DOVER COUNCIL

21 DEC 2020

**Planning Application at Manor Field Frome-Saint-Quintin DT2-OHF**

MANOR FIELD
FROME ST QUINTIN
DORSET
FOR MR. & MRS. PALMER
SCHEME DESIGN
EXTENSION AND ALTERATIONS
GROUND AND FIRST FLOOR PLANS
SCALE 1:50
DATE October 2020
DRAWN SP
19/129/SKI
A

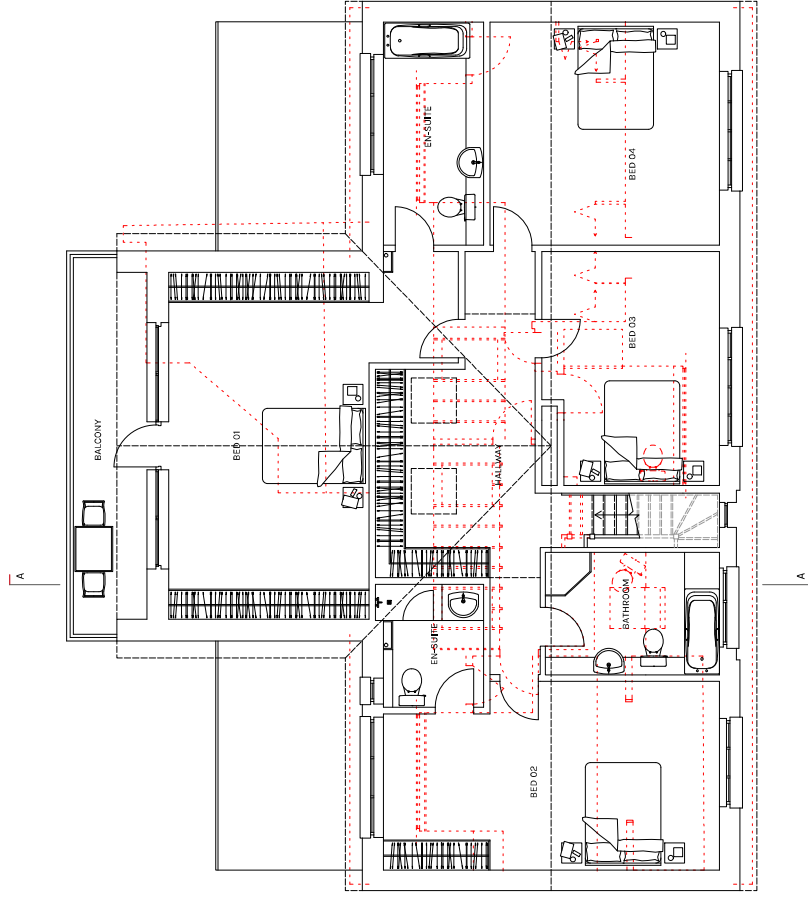
**There is a simple piece of Maths, that applies to their Dwelling. The more you go up and out. The less Light there will be in my Kitchen and Garden As its only 3m from my property.**

Therefore I am opposed to the Addition of an extra storey and new roof Plus a Two-story extension at the Northside of the existing Dwelling.

However, if extra Space is the object. Then may I suggest that a SINGLE Storey Extention be constructed. The full length of the rear of the dwelling. This would provide at least Three Extra large rooms. That would have **Zero Impact, on my property or Manor Farm.**

If a two-storey Extention is an absolute necessity, for this Dwelling. Then construct it at the Extreme South end of the existing dwelling. **Where it will have Zero Impact, on my property or Manor farm.**
